OXFORDSHIRE COUNTY COUNCIL'S RESPONSE TO CONSULTATION ON THE FOLLOWING DEVELOPMENT PROPOSAL

Application no: 14/01888/F-3

Proposal: Erection of two local centre buildings - one to contain four apartments (3 x 2 bed and 1 x 1 bed) over one retail unit and a surgery and the other to contain four apartments (2 x 1 bed, 1 x 2 bed and 1 x 3 bed) over three retail units and a nursery

Transport

TITLE  
 Longford Park, Village Centre  
 Landscape Hard and Soft Plan 1 of 2

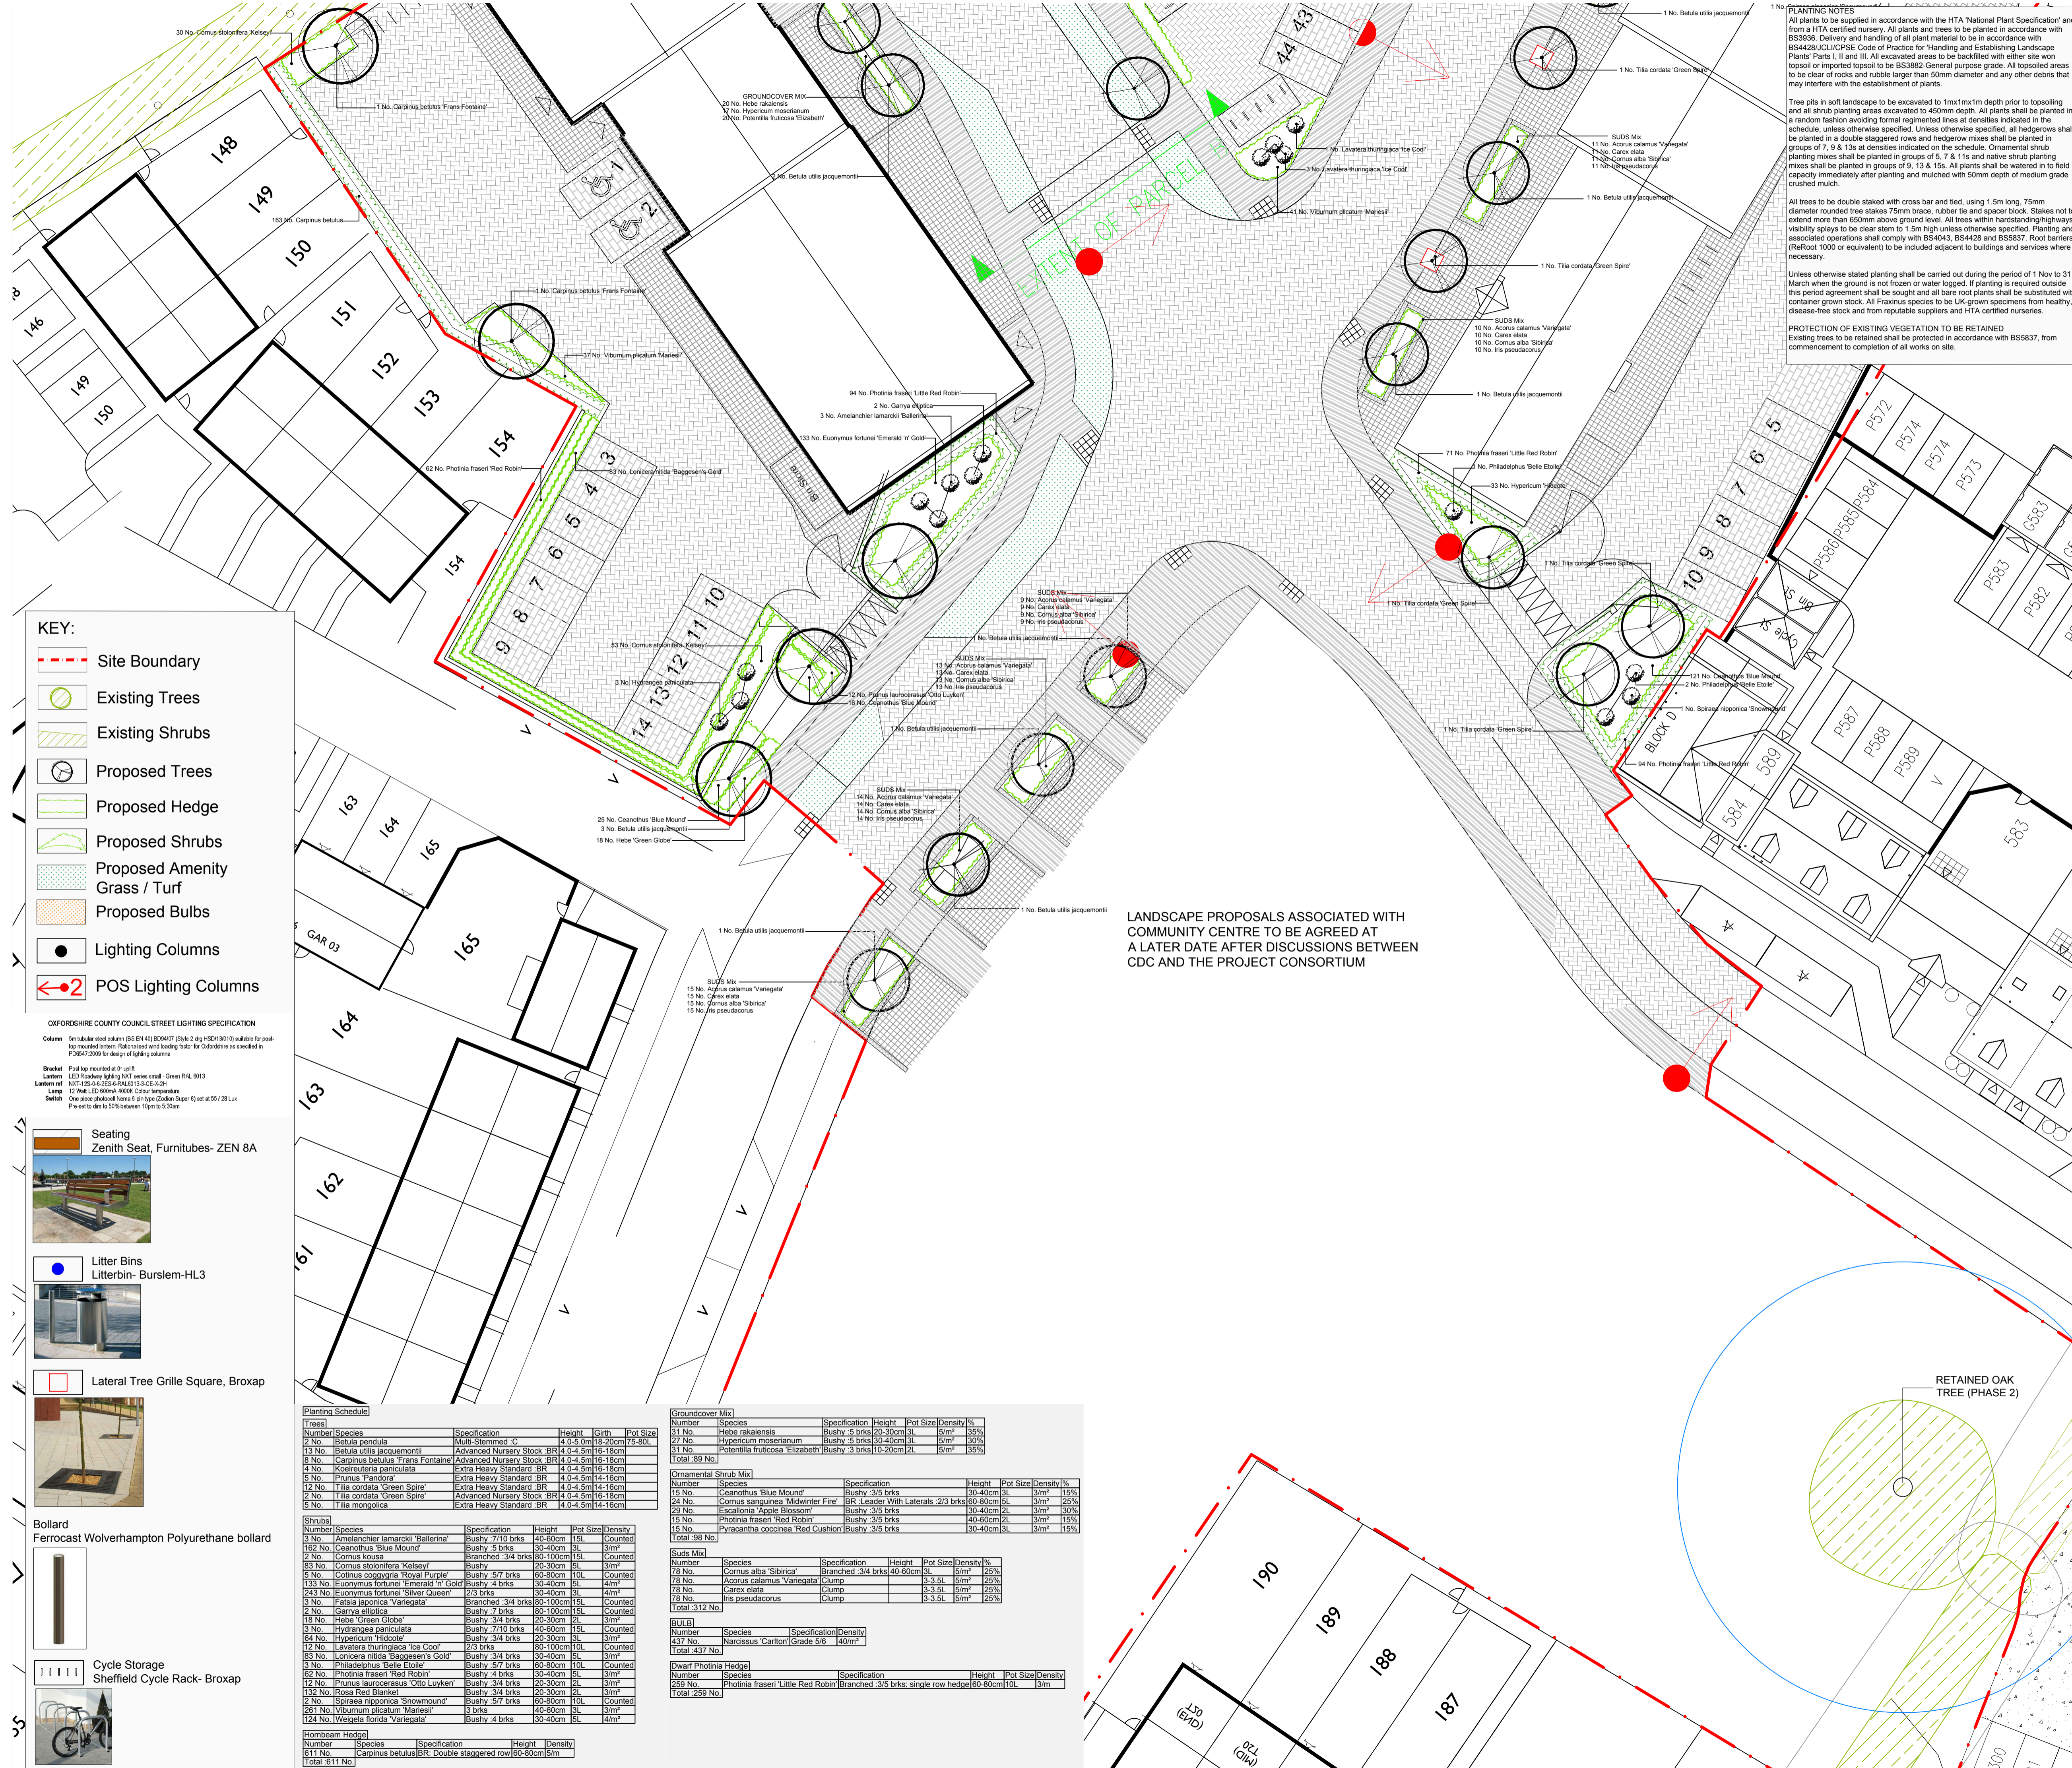
- I am concerned that the correct kerblines with the service bay outside the convenience store is still not shown. Also, I requested in my previous response confirmation of the route taken by deliveries from this bay into the store, which has not been provided.
